# Roadway Plans\_V1.pdf Markup Summary

# CLEARWAY FILING NO. 2, LOT 5

# CONSTRUCTION PLANS

MAINT AND ACCESS ROADWAY PLAN

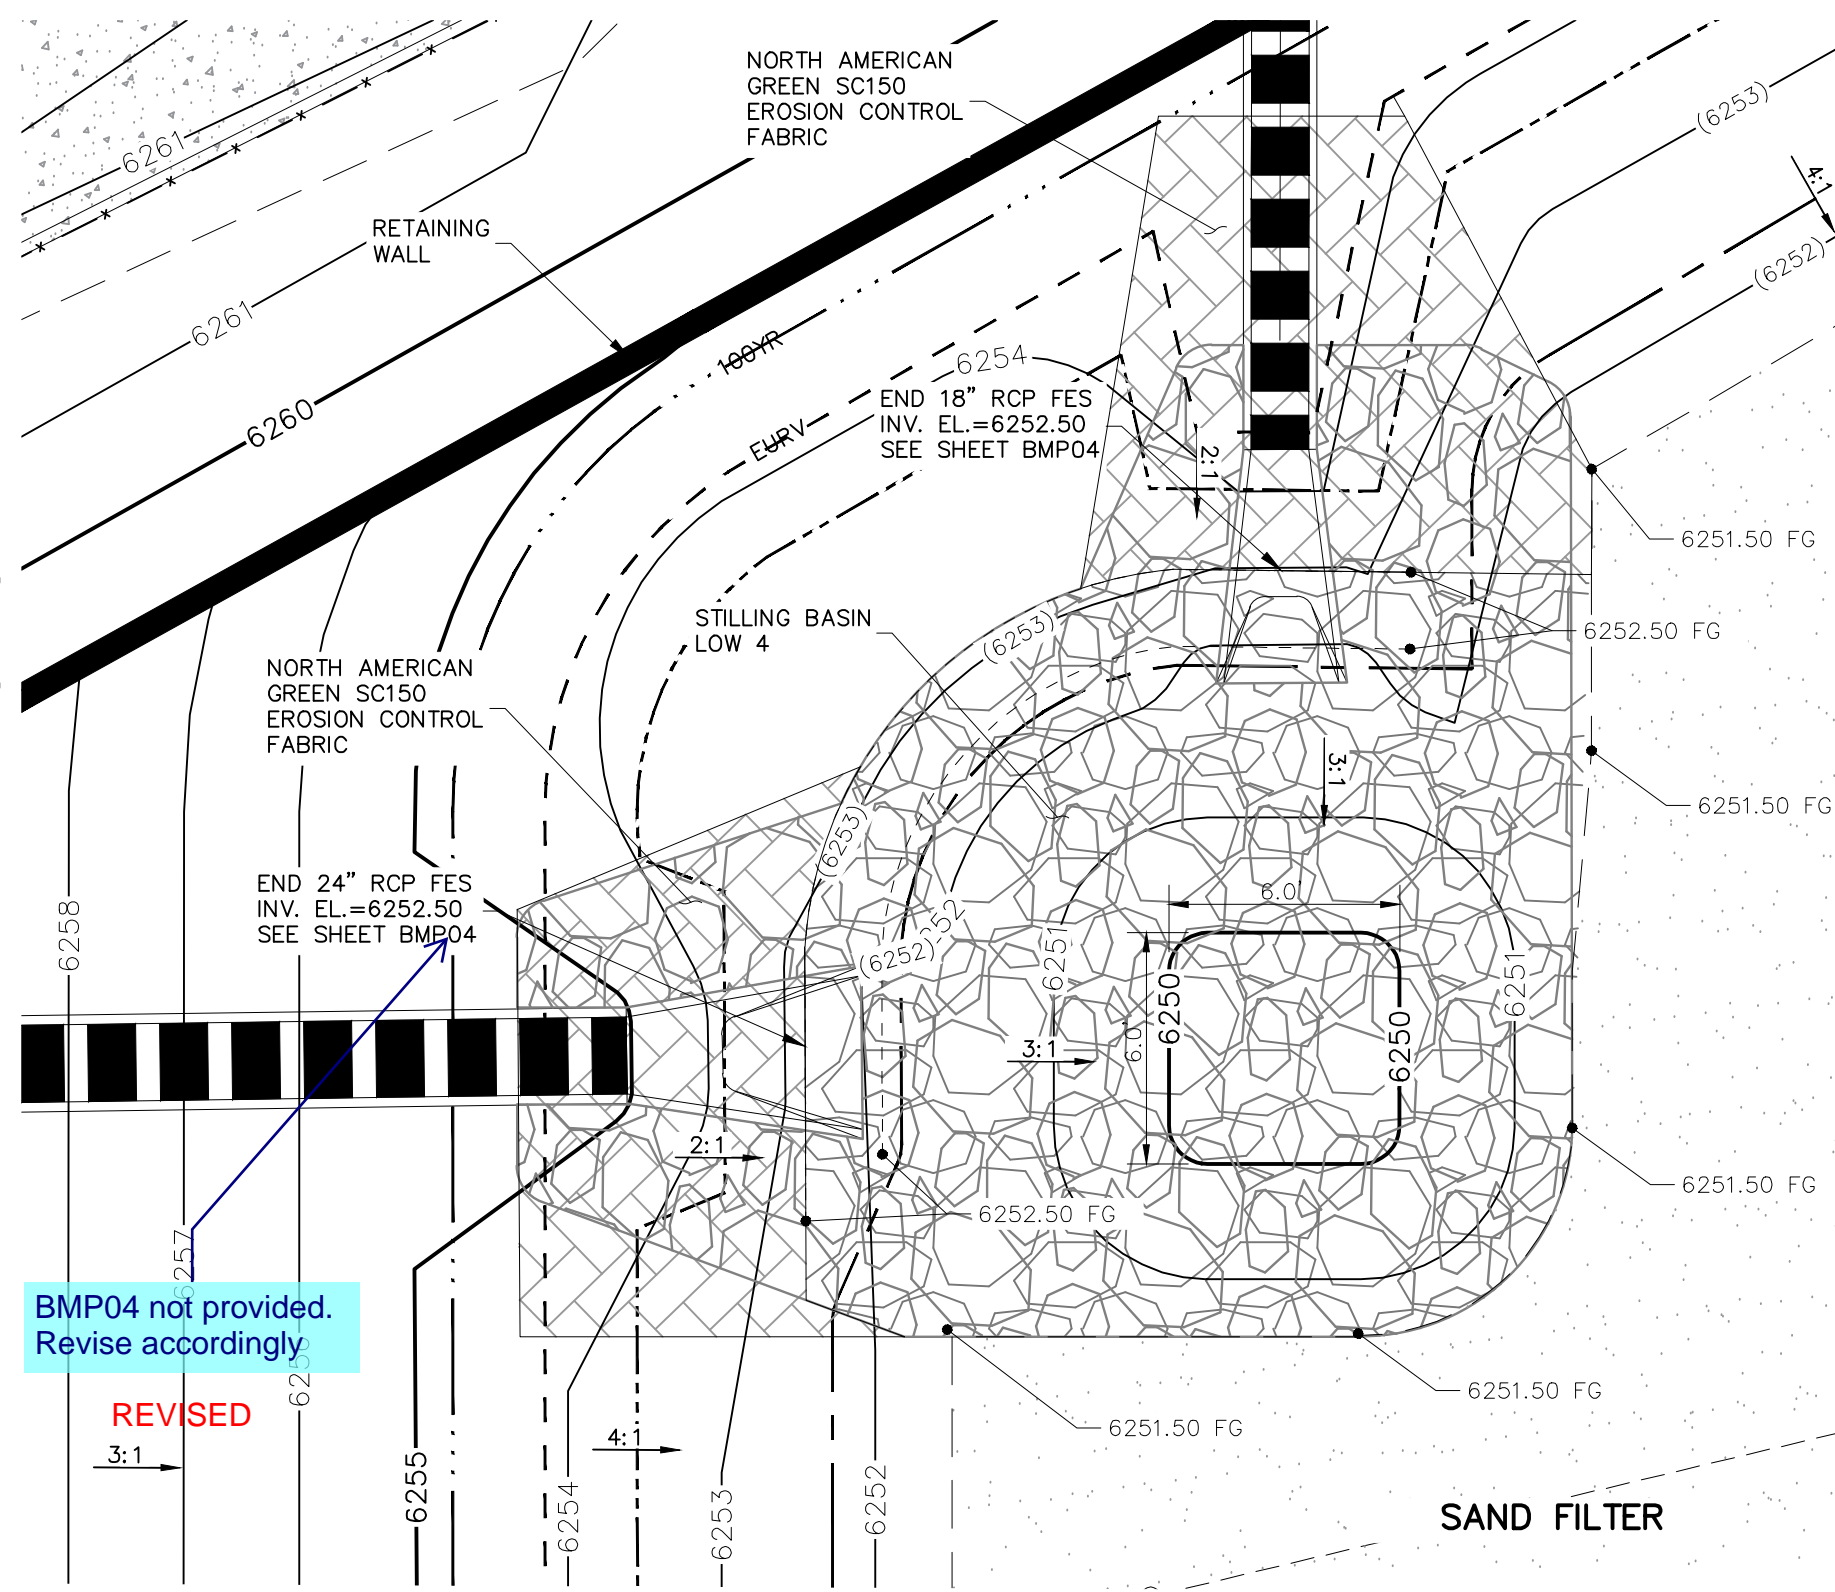
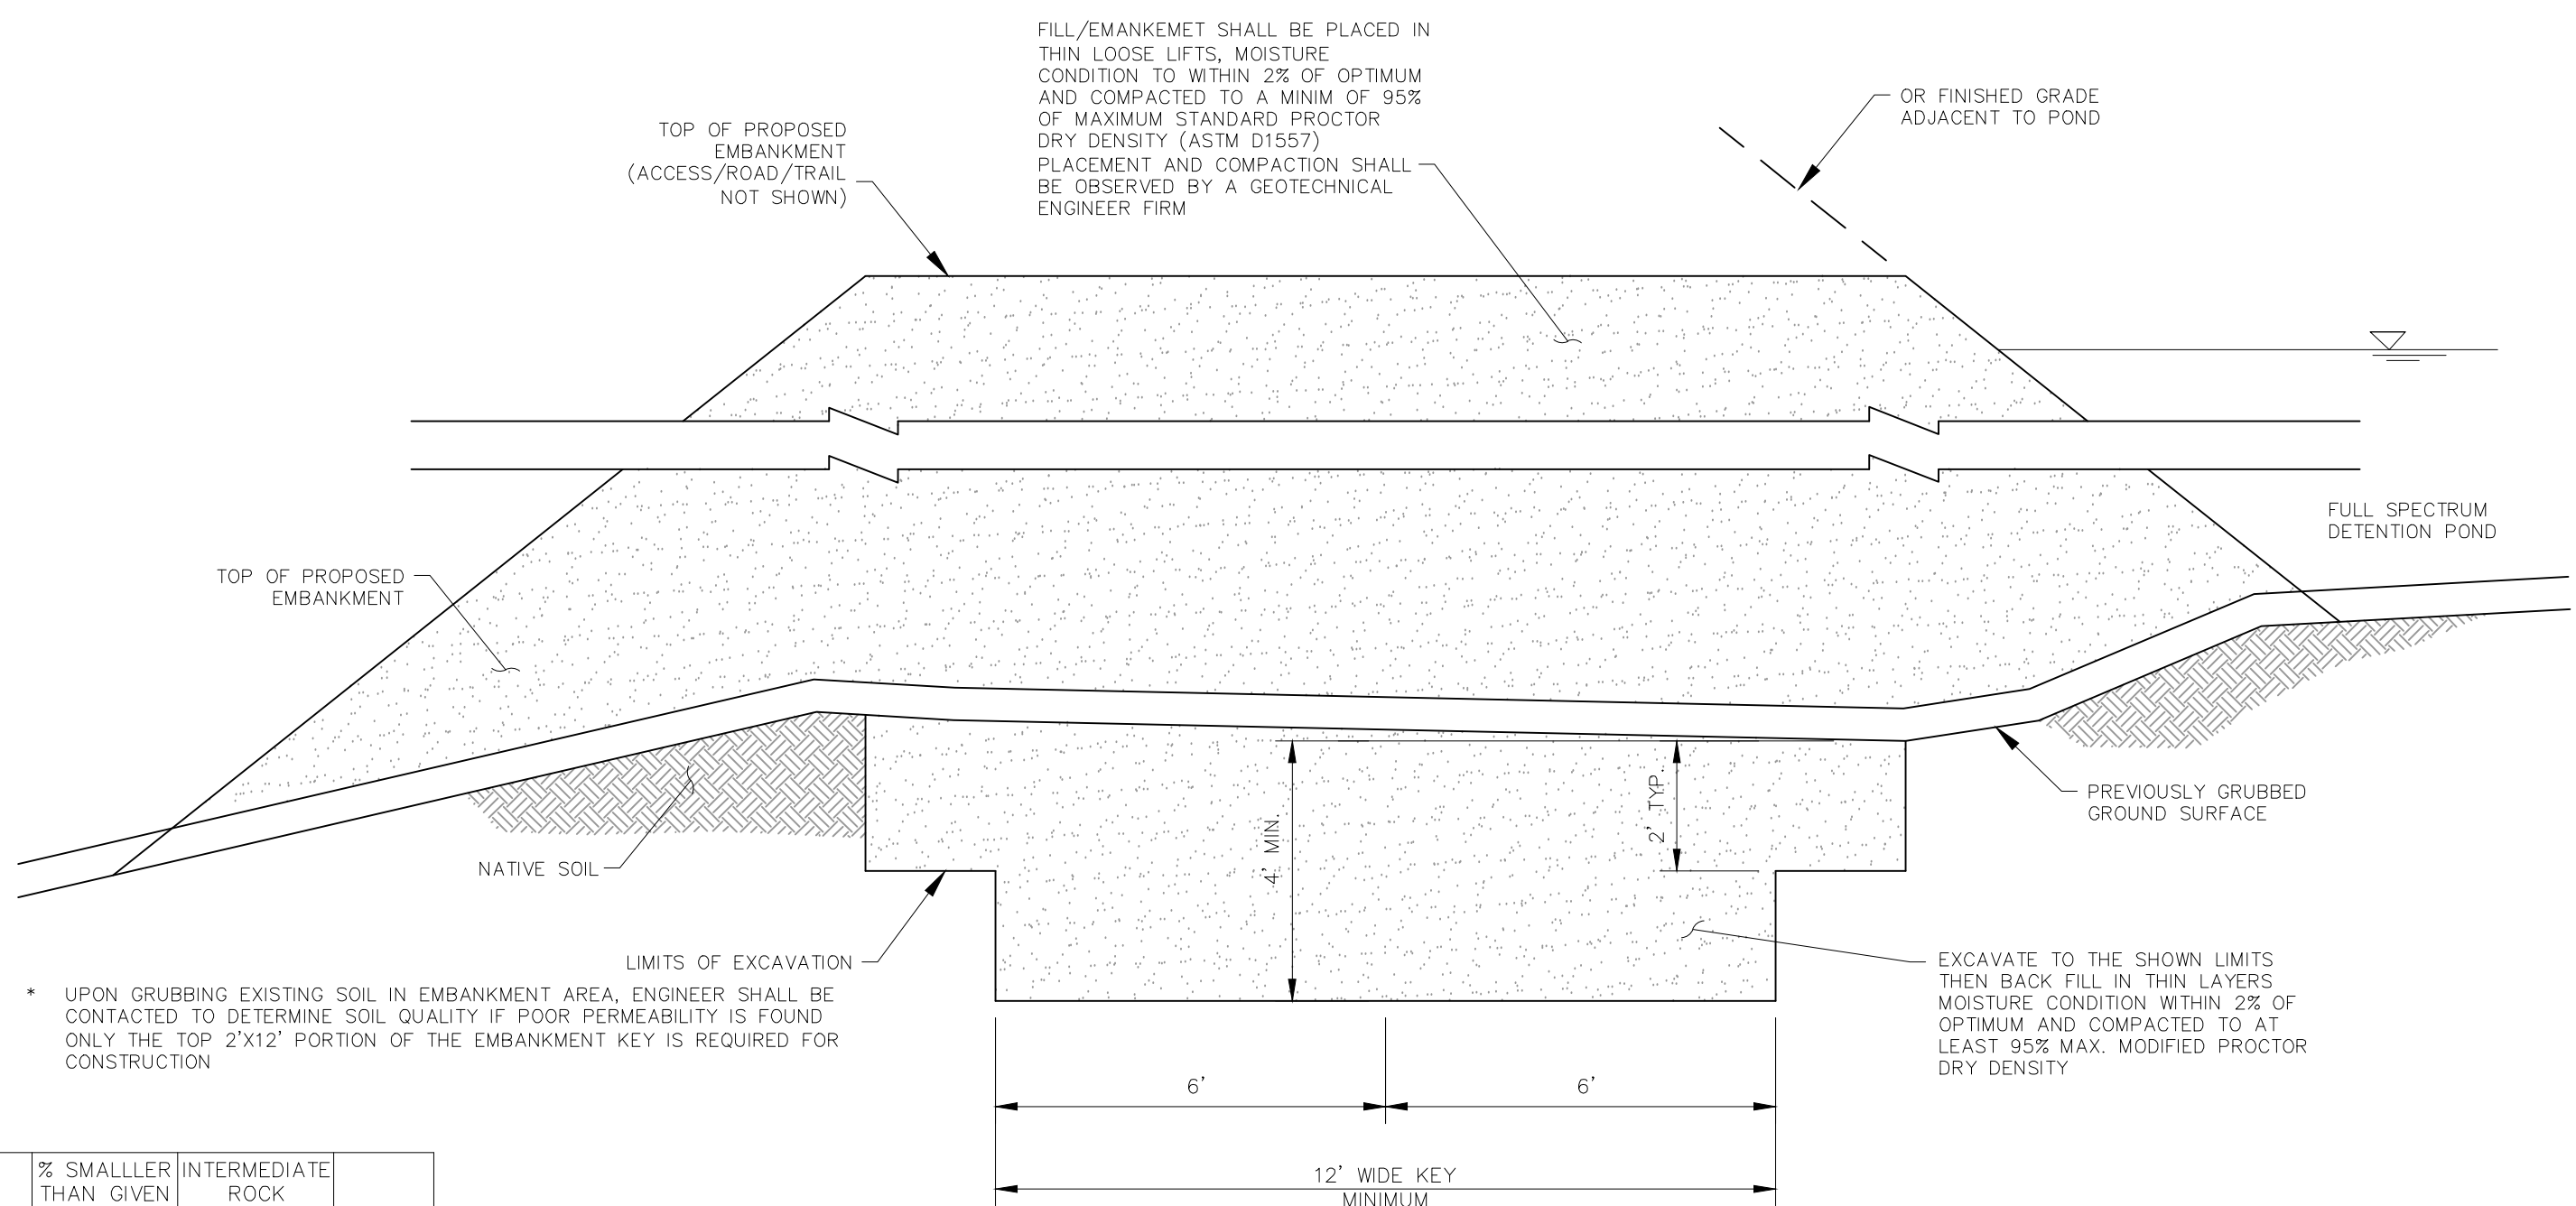
provide sizing calculations in drainage report and show dimensions on plans

Stabilized access ramp shall be a minimum of 15ft wide and no greater than 12% slope, in accordance with DCMv1, Chap 11.2.2. --Unless the anticipated maintenance vehicles and equipment can safely access the pond at specified road width. Properly document this in the Pond O&M manual.
